Sent: 20 January 2013 19:58
To: Planning
Subject: Welwyn Hatfield Council Online Planning - Comment

Application Number: S6/2012/2608/MA

Specific comments relating to the fencing of the Church; Track Entrance to the Estate to the west of the graveyard.

TITLE
Proposed Boundary Fence (60f6)

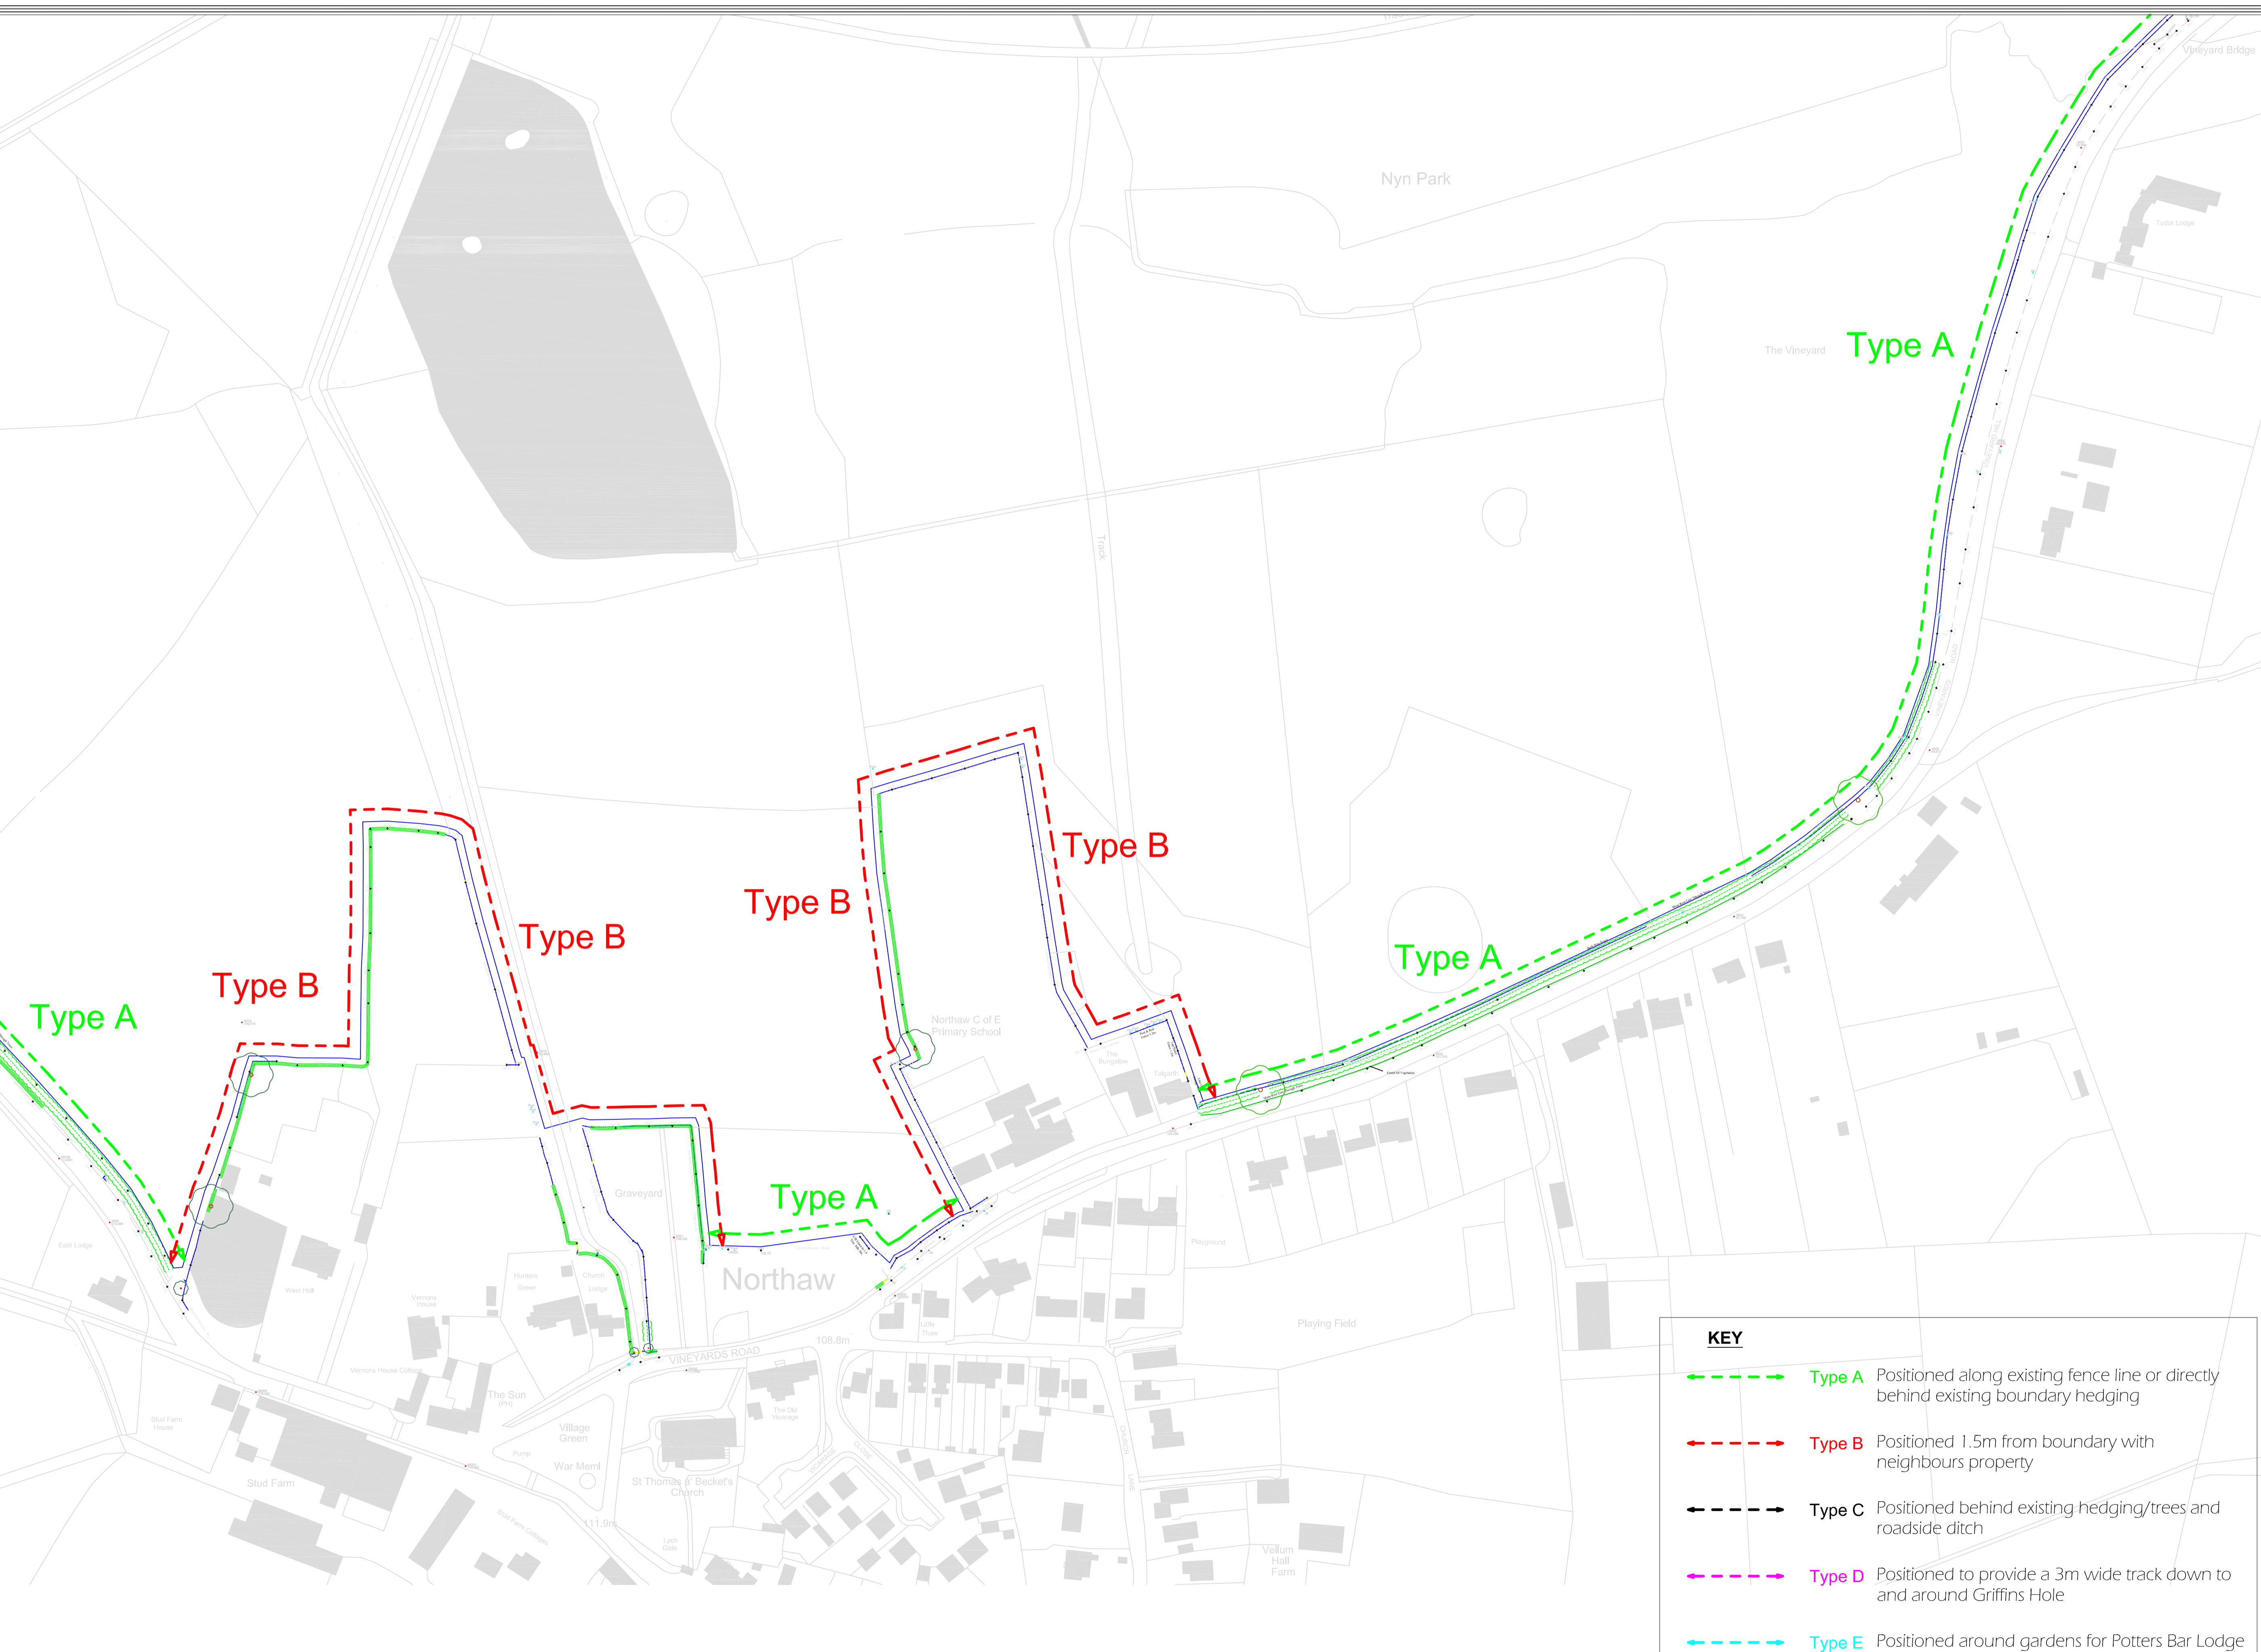
Since the primary security gates are shown to be situated close to the north-west corner of the graveyard, 2m fencing is not warranted to achieve the estate boundary security at the margins of this track. Submitted plans do not indicate the exact position of proposed fencing or the gated restrictions to access from Vineyards Rd.

Fencing bordering the property of Church Lodge EN6 4NZ should respect the height of the existing hedging to minimise the visual impact on the rural outlook.

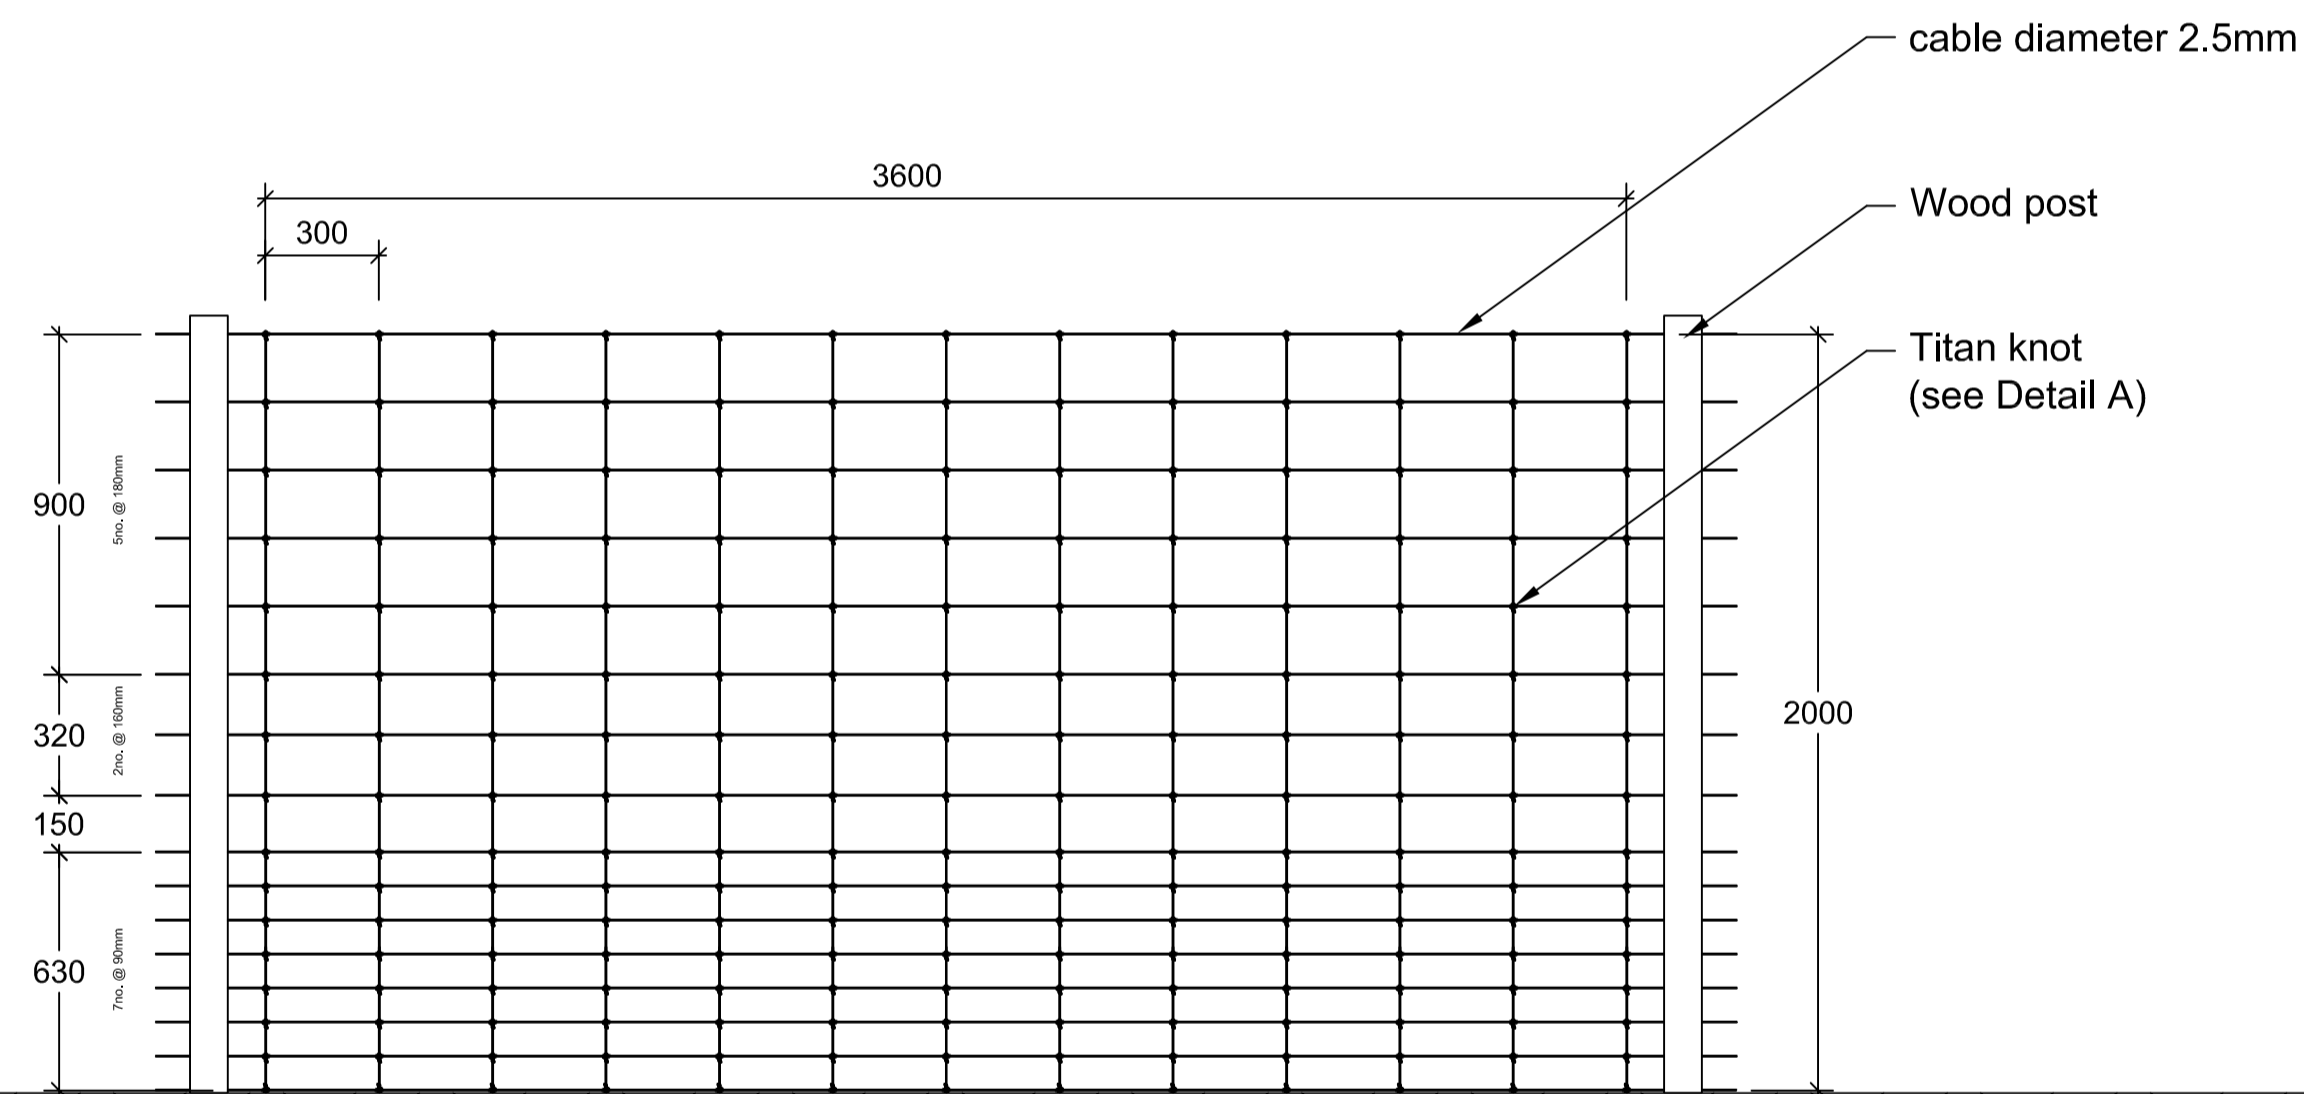
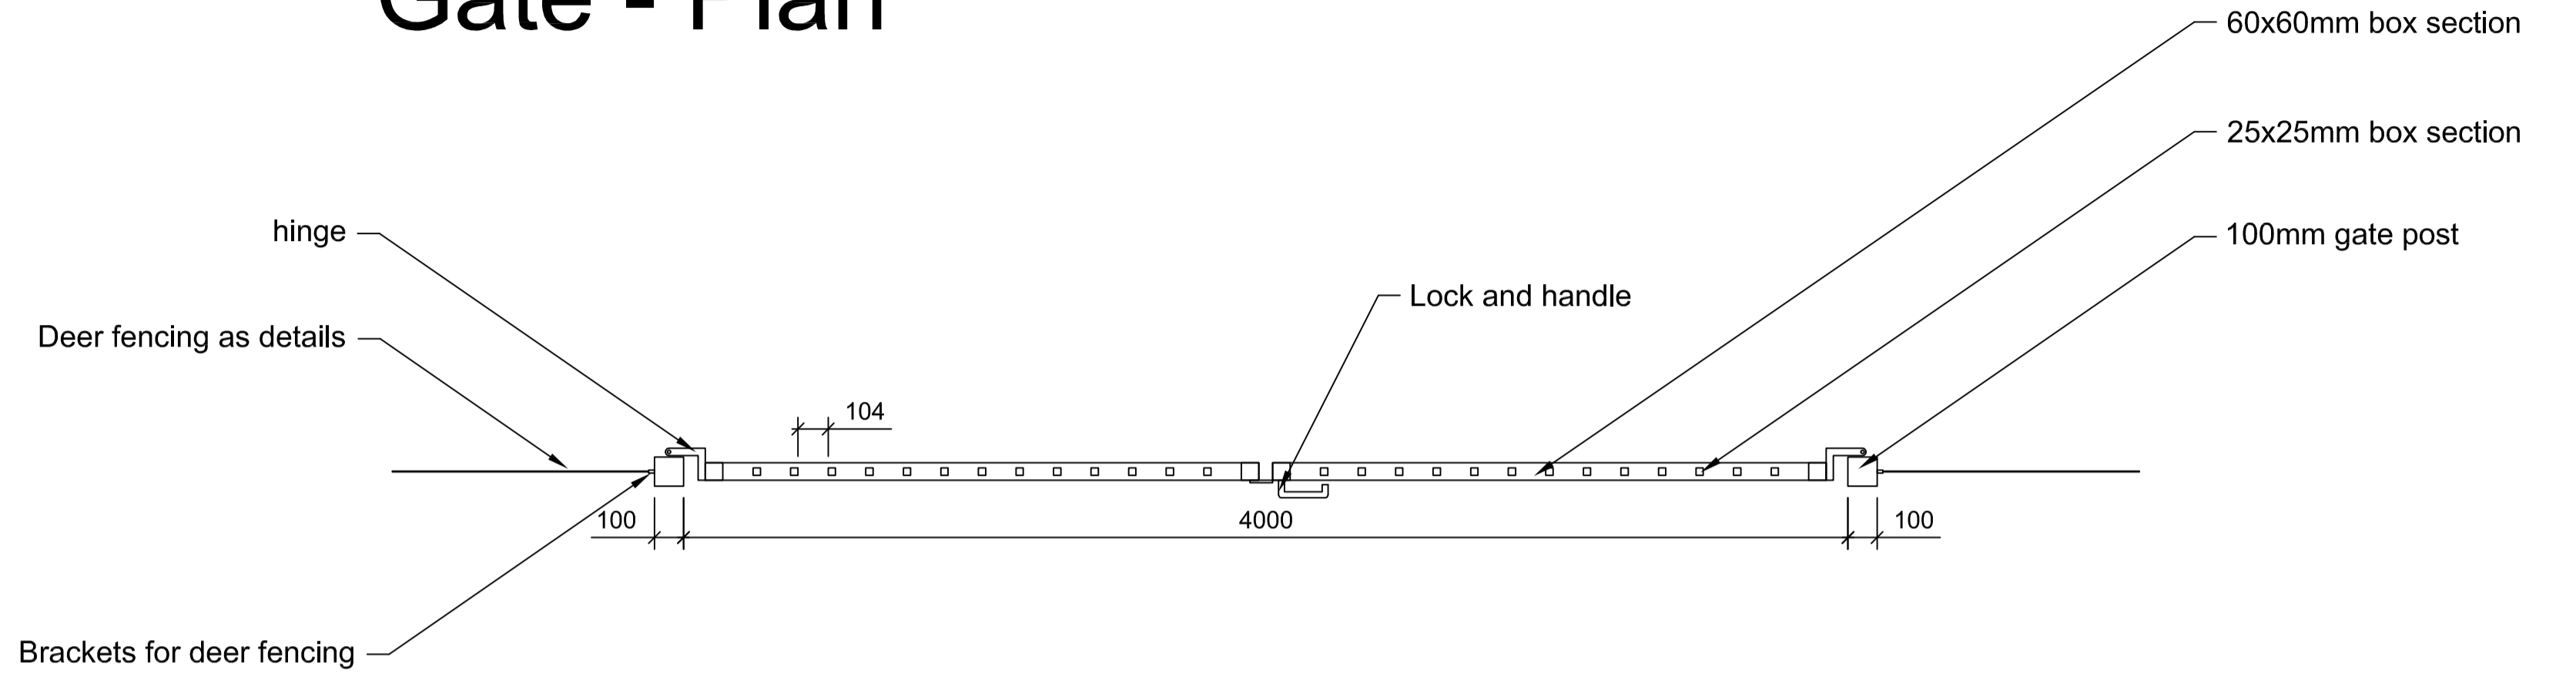
Whilst accepting the need for increased estate security a 2m fence would adversely visually impact on the predominately rural environment.

At boundaries with properties, where existing maintained hedges are in place, a set-back is necessary to allow proper hedge growth and maintenance, and the height of new fencing should be specified to maintain the visual amenity.

At boundaries with properties where existing well maintained fences are in place, the height of existing fencing should be respected to maintain the visual amenity.
